From: Tom Errico <thomas.errico@tylin.com>
To: Jean Fraser <JF@portlandmaine.gov>
CC: David Margolis-Pineo <DMP@portlandmaine.gov>, Katherine Earley <KAS@port...>
Date: 9/17/2014 7:37 PM
Subject: 2282 Congress Street

Jean - I have reviewed the revised site layout, construction plan, and the off-site improvement plan and offer the following comments;

**TYPICAL SECTION
 STATE ROUTE 22 (CONGRESS STREET)
 STA 96+26 TO STA 98+51**
 N.T.S.

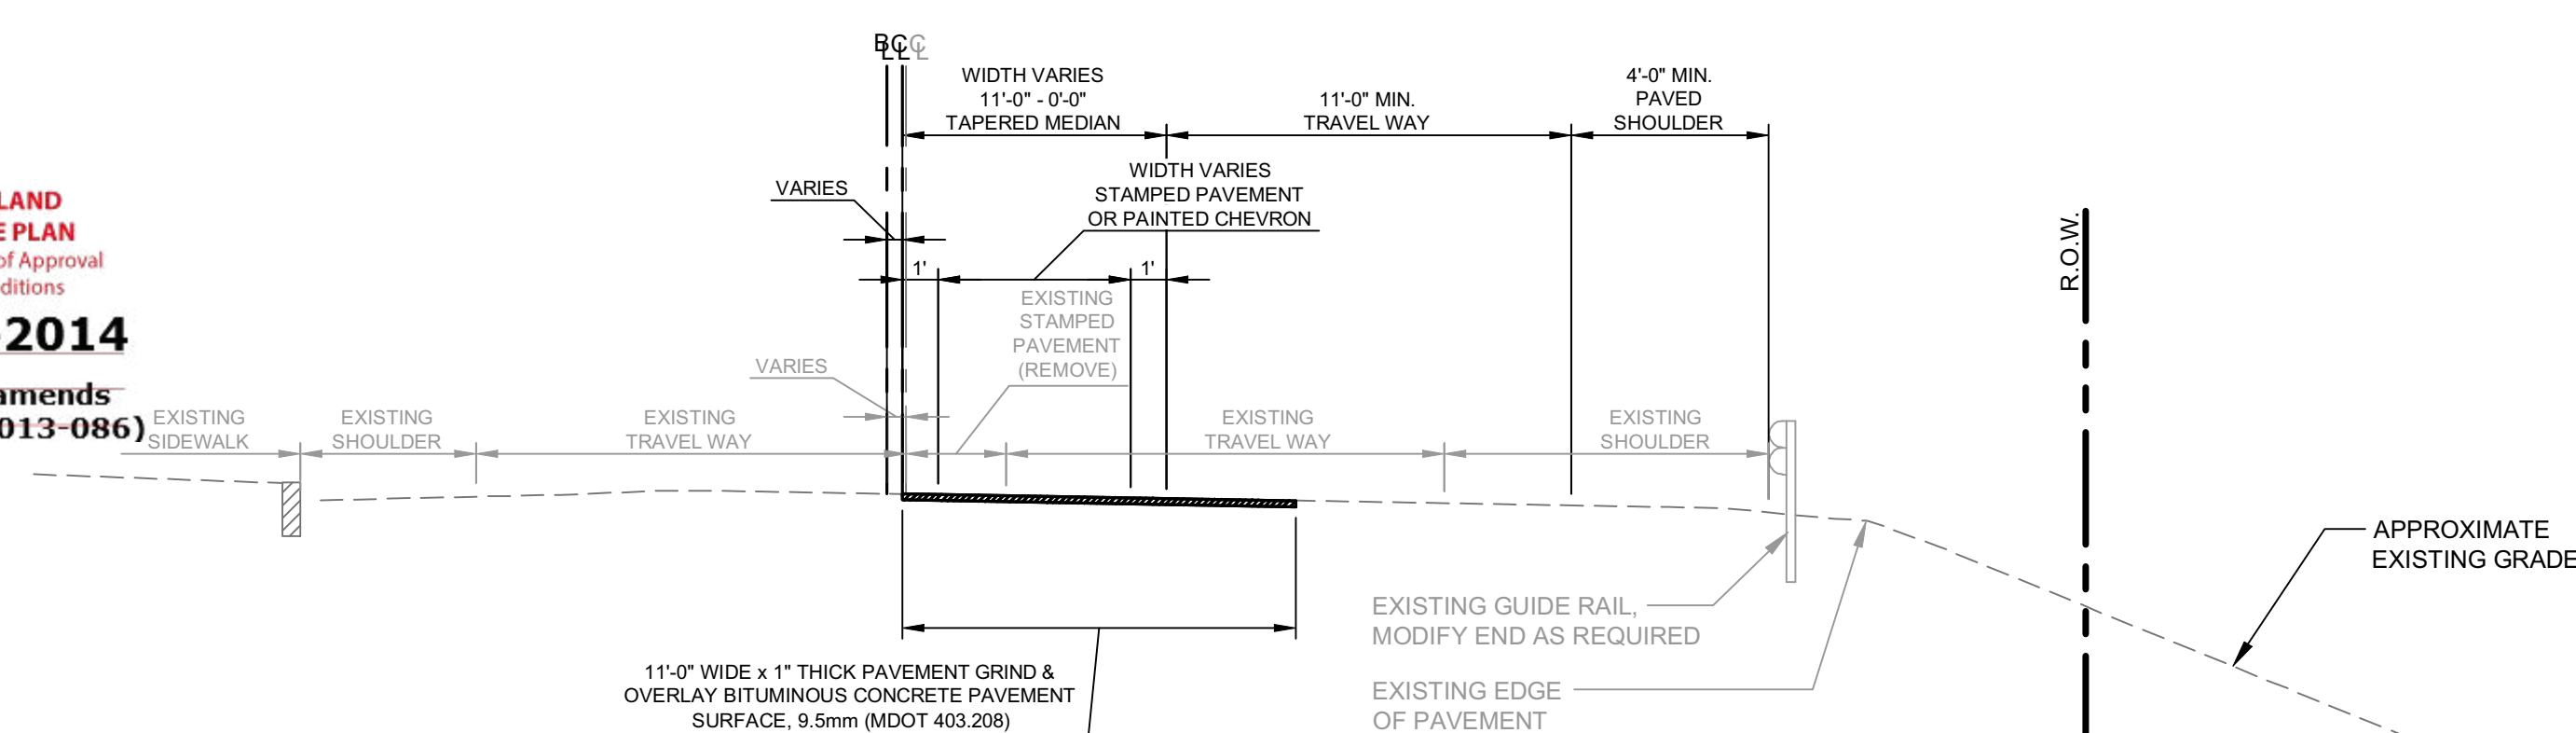
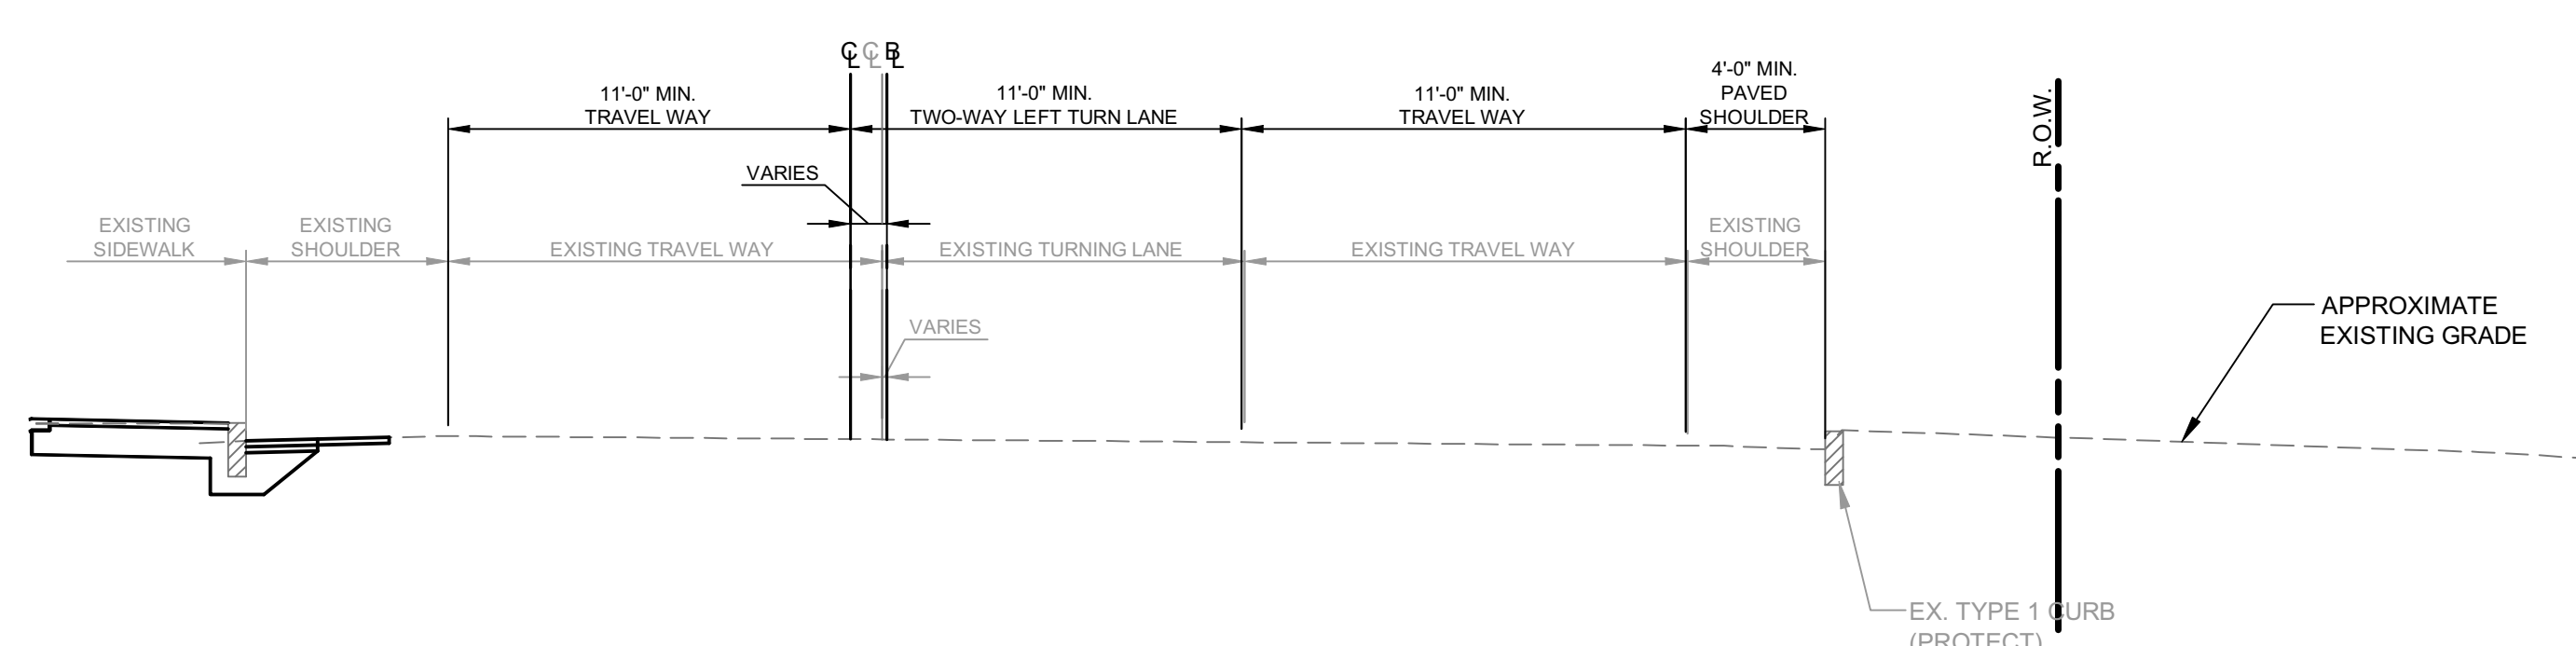
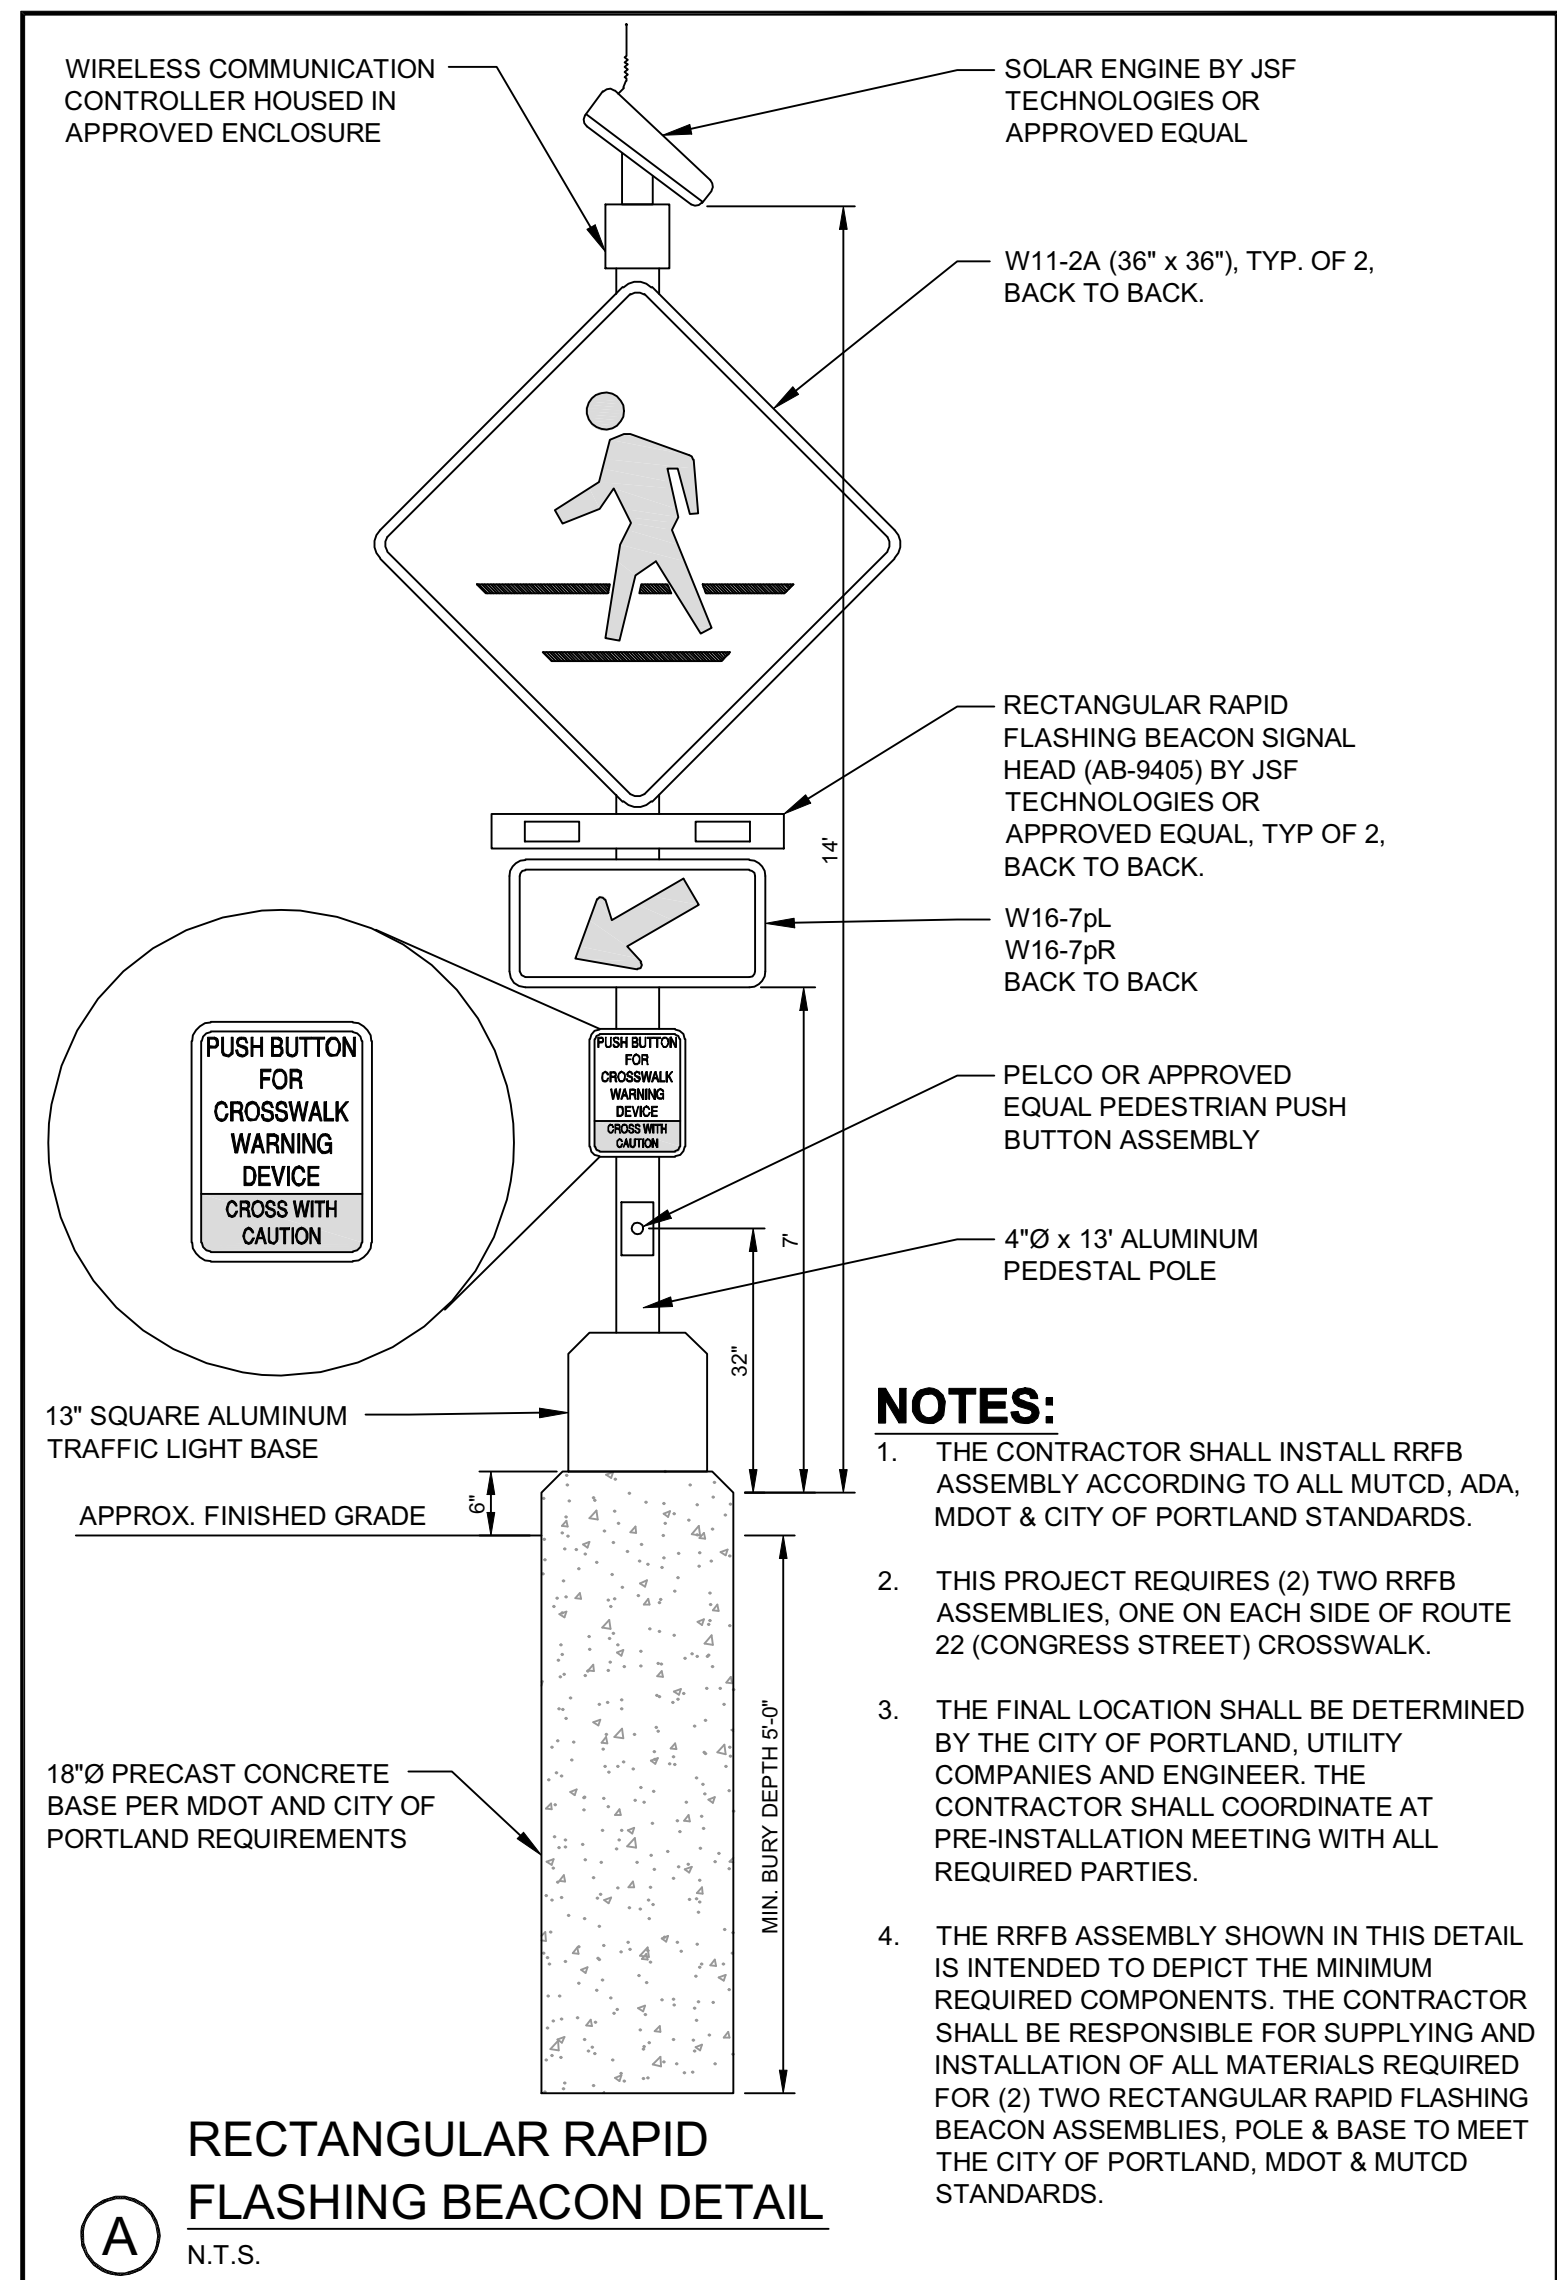
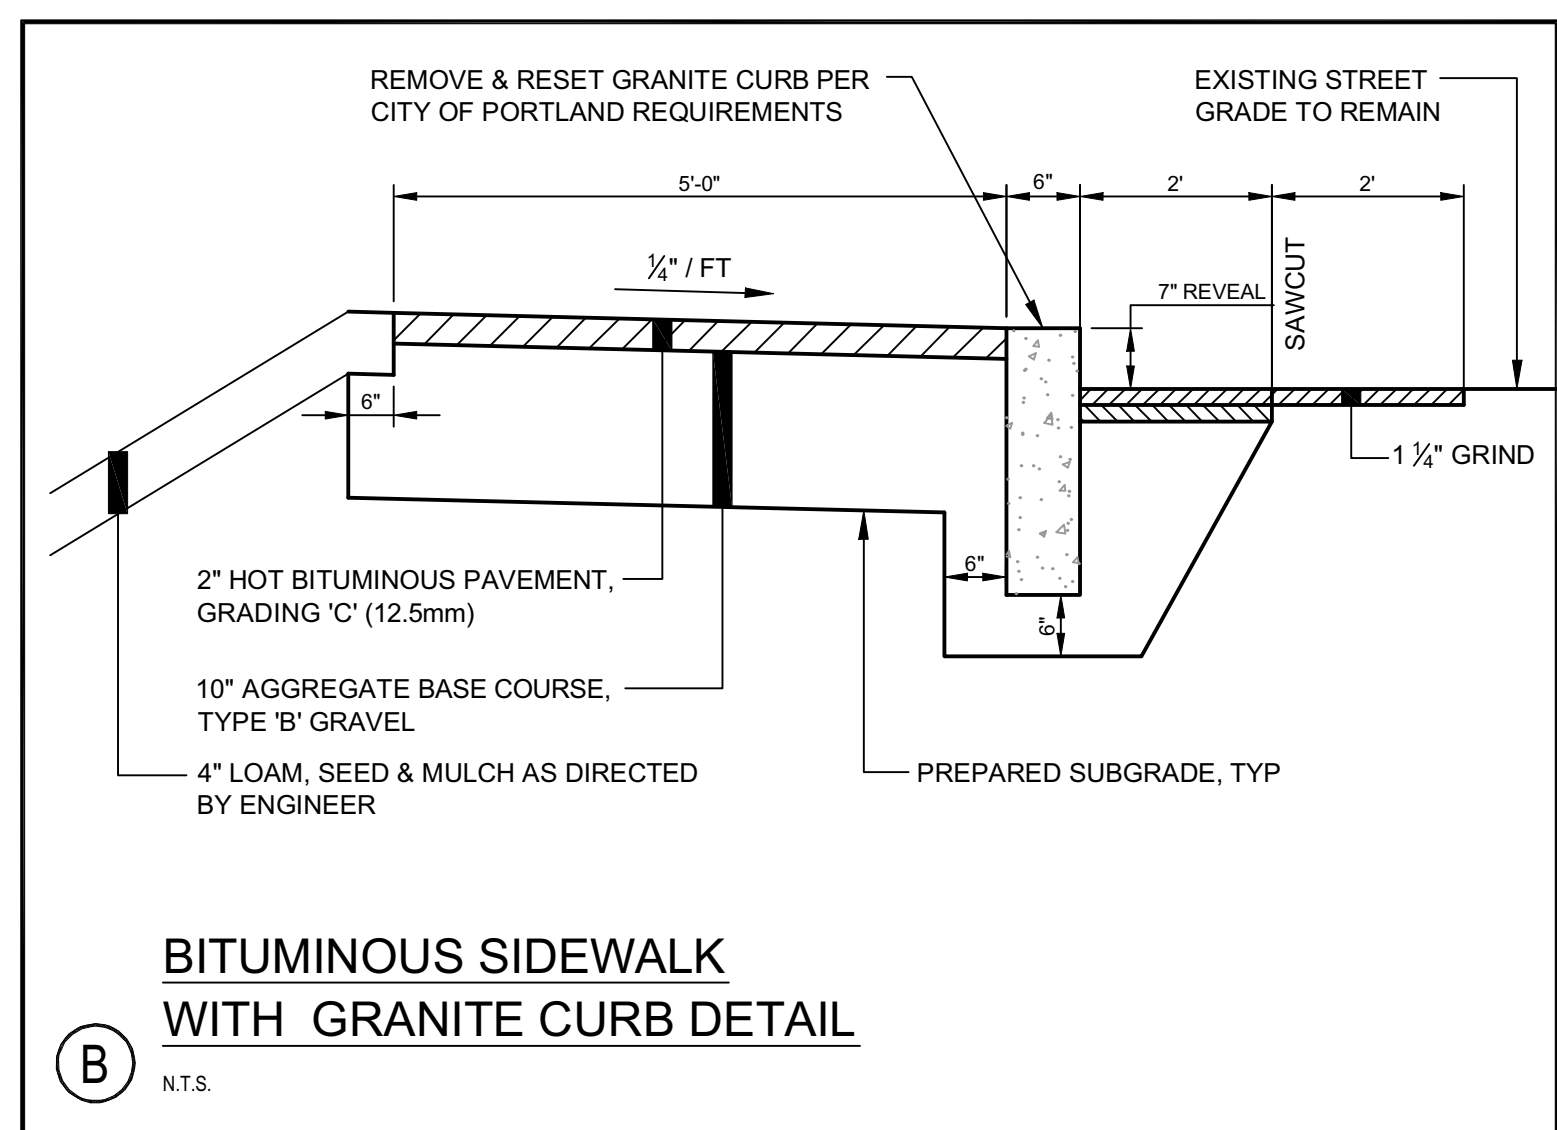
- * I find the site plan layout to be acceptable and I have no comment.
- * I find the construction plan to be acceptable with the requirement that a variable message board (s) be provided that notes use of Skyway Drive as an alternative route during construction.
- * The following are my comments regarding the improvement plan:
 - o The applicant should note why a minimum 5-foot shoulder is not provided (Please confirm that 4-feet is the existing width that the project is matching into)
 - o A detectible warning panel shall be installed on the easterly corner of Blueberry Road.
 - o Right-of-way boundaries on the north side of Congress Street should be provided and it should be confirmed that all activity will occur in the public right-of-way.
 - o A method for removal of existing conflicting pavement markings shall be provided for review and approval.
